Comments from Environmental Health and Private Sector Housing:

APPLICATION **BR/190/17/PL**

Site Address: 76 London Road Bognor Regis PO21 1DD

Description of Works:	Two & part three storey rear extension for an additional 4 No. dwellings.
------------------------------	---

Proposed Second Floor Plan

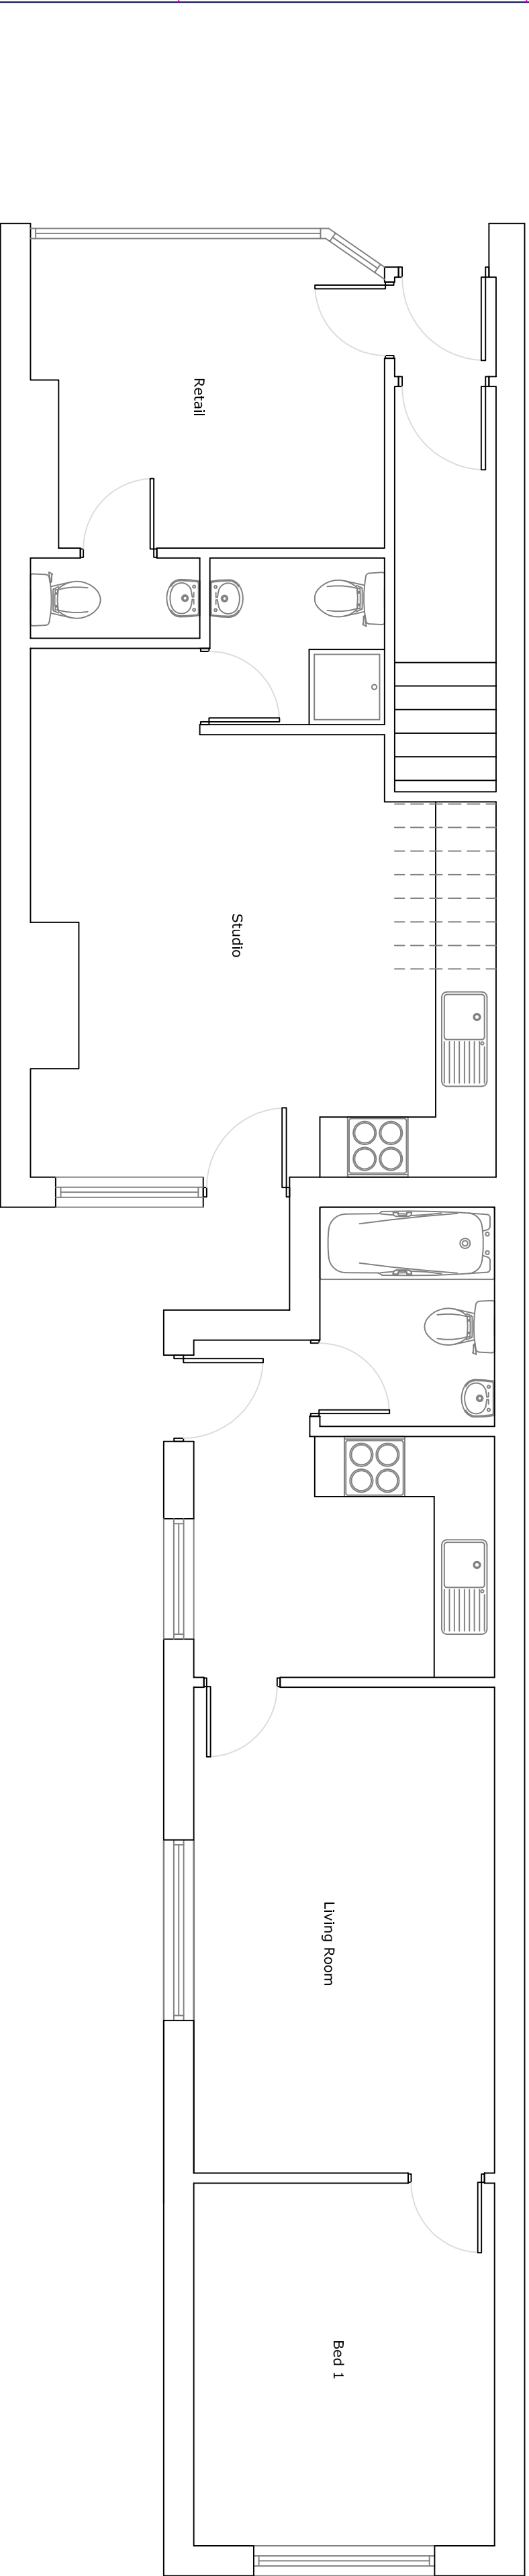
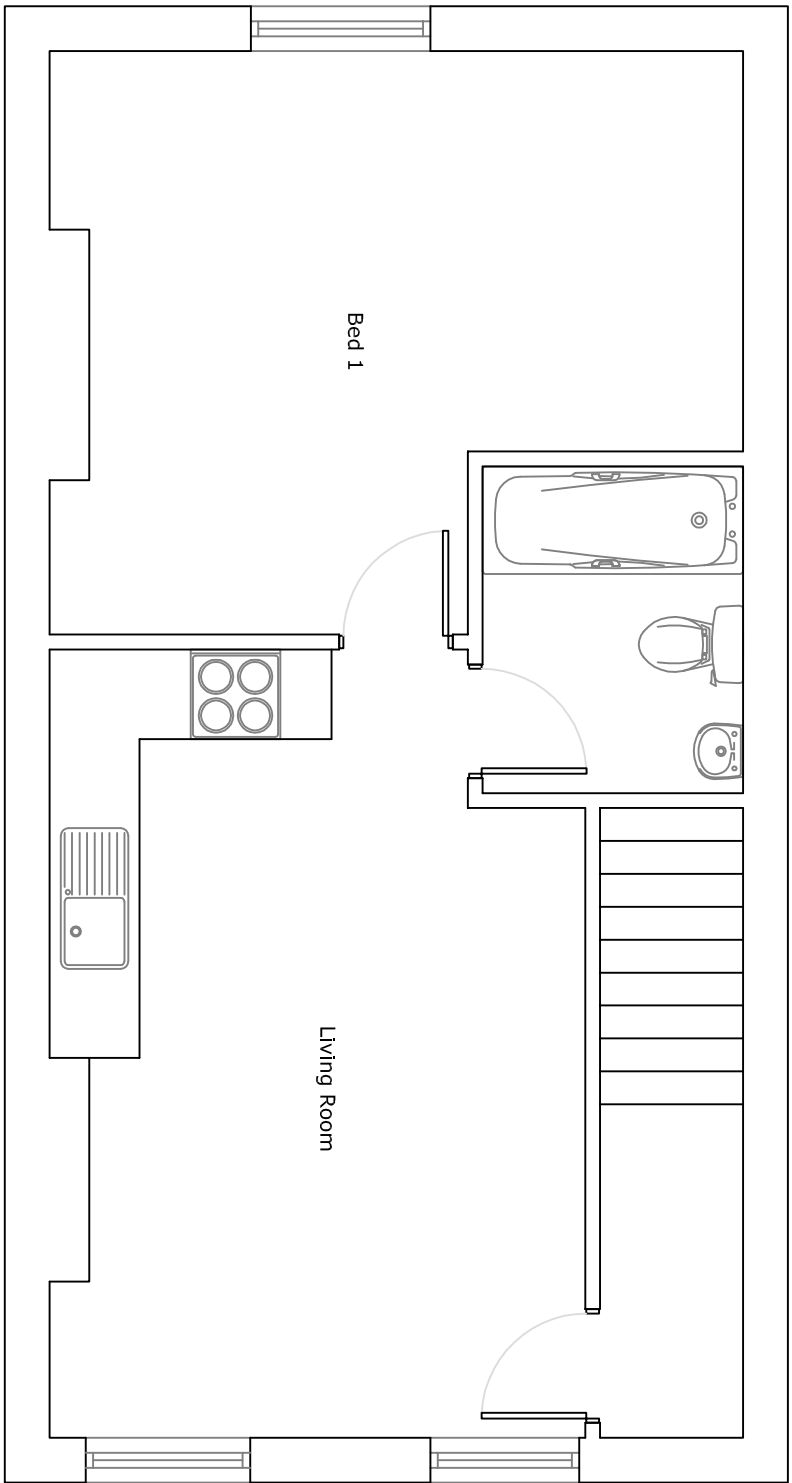
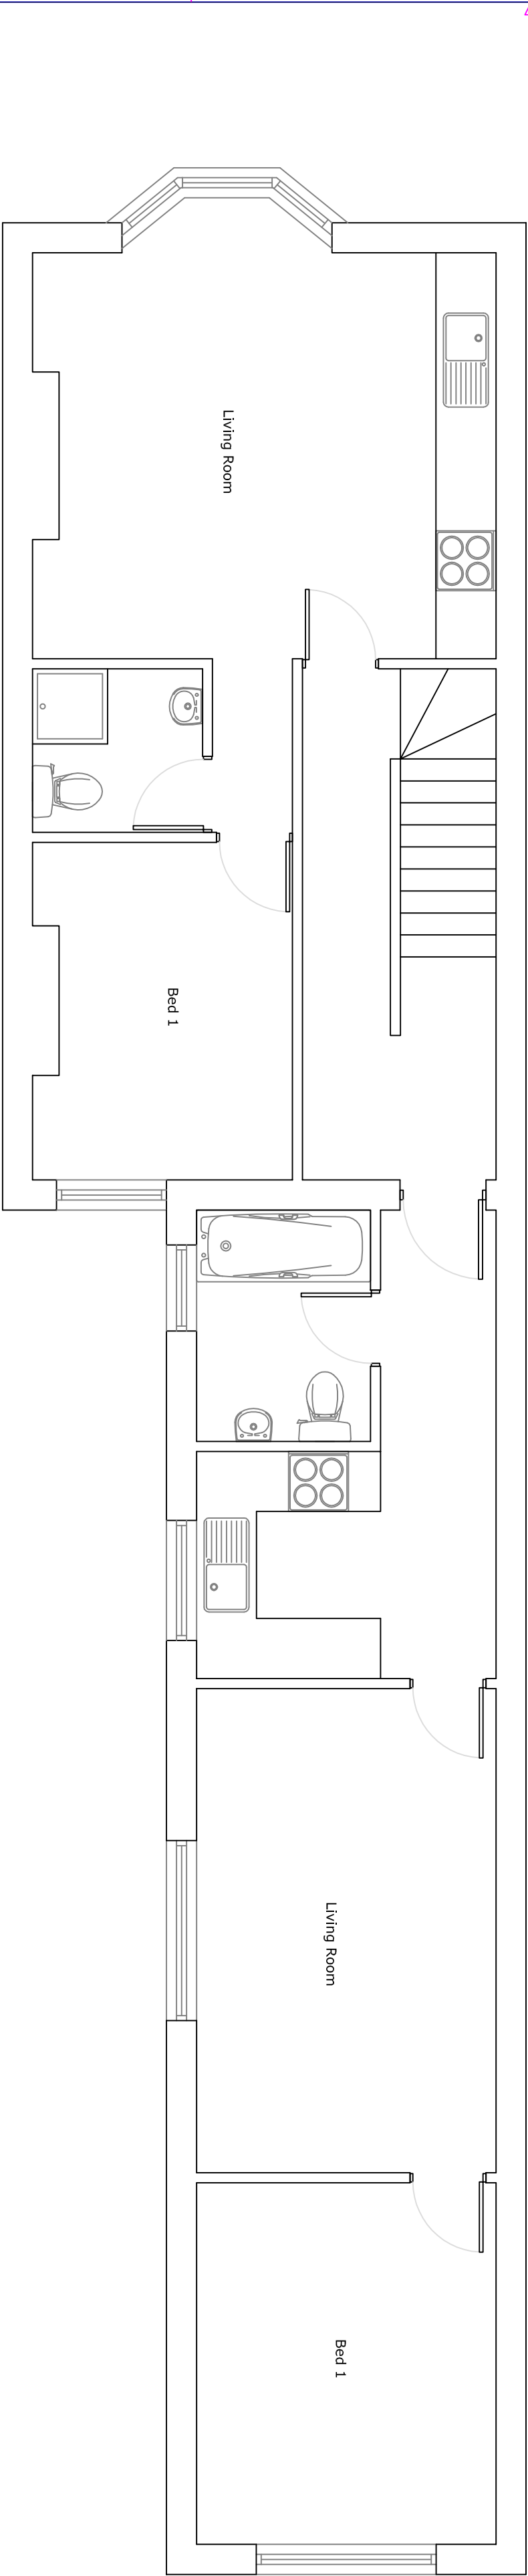
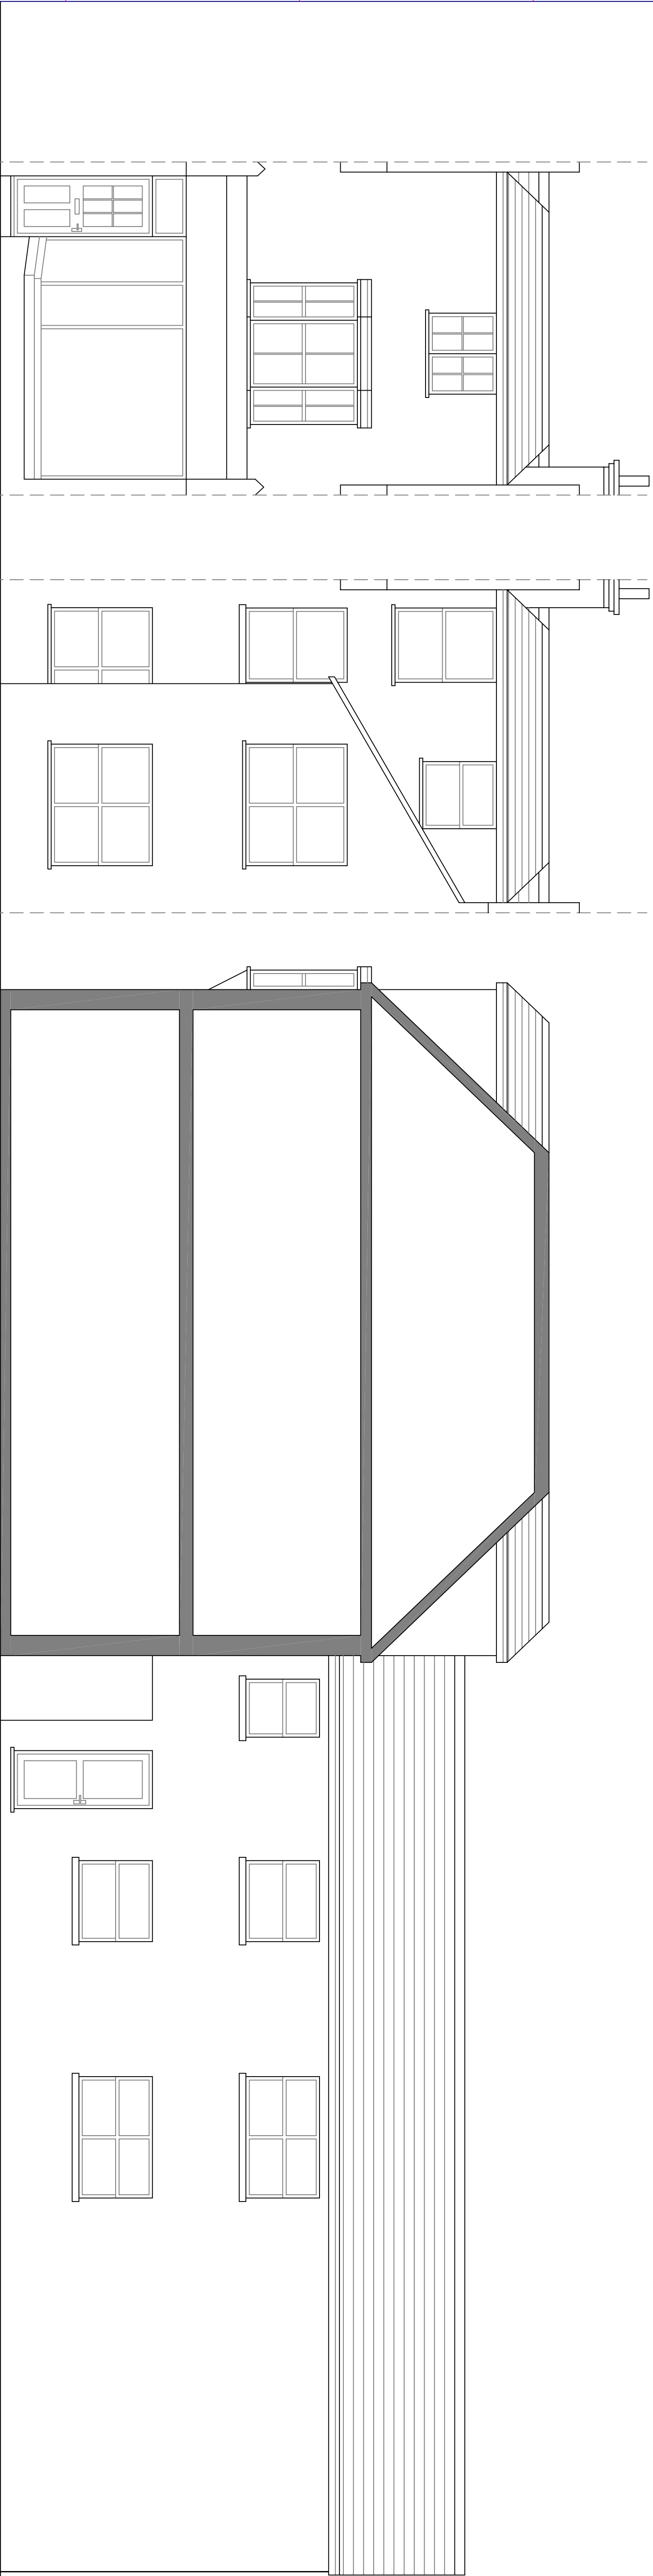
- A room where the only escape route is through another room is termed an "inner room" and poses a risk to its occupiers if a fire starts unnoticed in the outer room. The escape routes from all flats is via the kitchen, this can be overcome by ensuring that the window in the bedroom is an escape window and adequate fire protection within the flat. However, an escape window is not acceptable above 4.5m above ground level therefore the layout on the second floor would need to be reconsidered.

- There should be adequate fire separation between the commercial unit on the ground floor and the residential flats above and to the rear.
